Proposed Lake Lothing Third Crossing (TRO10023)

Associated British Ports (20013261)

**Summary of oral submissions made by ABP at the examination hearing held
on Thursday 7 March 2019**

Issue Specific Hearing 2 (Environment)

Figure 1 – SCC's LLTC proposed mooring plan

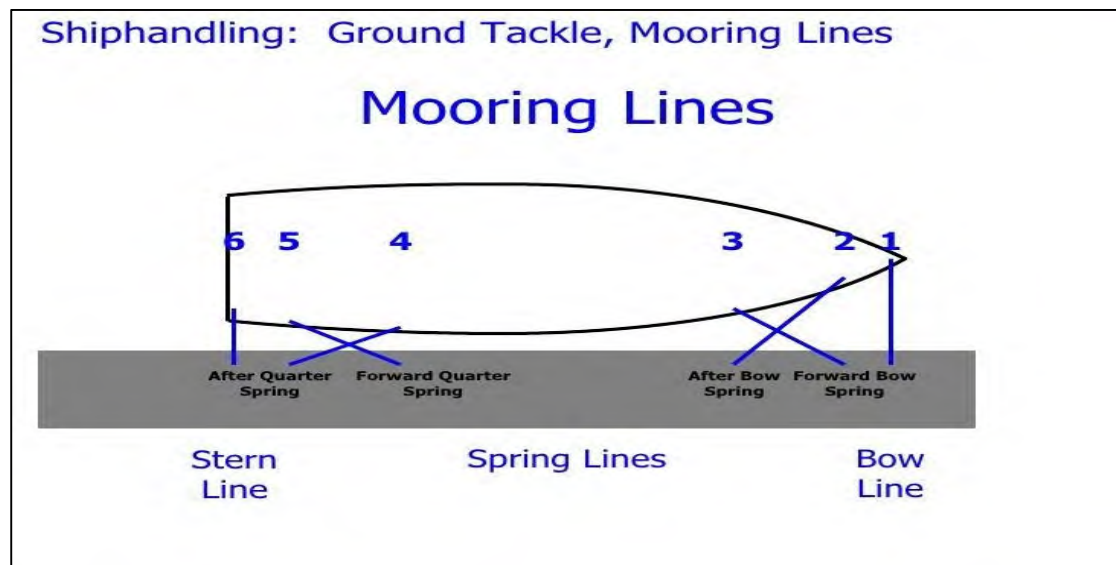
- 1.30 Captain Horton explained that the mooring arrangements for vessels as proposed by the Applicant in Impact of the Scheme on the Port of Lowestoft Report (Document Reference SCC/LLTC/EX/59) were not in fact practical in terms of the mooring uncertainties present in a tidal Port.

- 1.31 He explained that first a vessel would have to have the necessary mooring arrangements and fittings on deck, to accommodate the somewhat complex spread of lines as identified in the Applicant's Figure 1, but in practical terms far as the Port of Lowestoft is concerned, the mooring process suggested by the Applicant's marine consultant would only work if the elevation of the moored vessel's mooring decks were very closely aligned to the elevation of the quay (the height above the water line) – in that for the moorings to work safely, there could be no disparity in height. Such arrangements would only be possible if no adverse weather conditions, effects of passing vessels, or changes in height disparity between vessel and quay were anticipated during the vessel's stay alongside.

- 1.32 In reality, however, for vessels typically moored in the Port the disparity in height between the vessel and quay would be significant - up to about 5 metres in certain instances. To try to moor a vessel in the manner suggested by the Applicant would be unsafe and impractical. Neither for that matter would it be a particularly efficient way of mooring.

- 1.33 In addition, the mooring methodology proposed by the Applicant would not protect the Port's bollards. The sheer forces acting on the bollard - the forces acting vertically as well as horizontal would be quite significant. Captain Horton pointed out that he had been a Master, Mate and Second Mate of vessels for many years before working at the Port, and he would not consider the arrangements proposed by the Applicant to be either a safe or achievable method of mooring at Lowestoft.
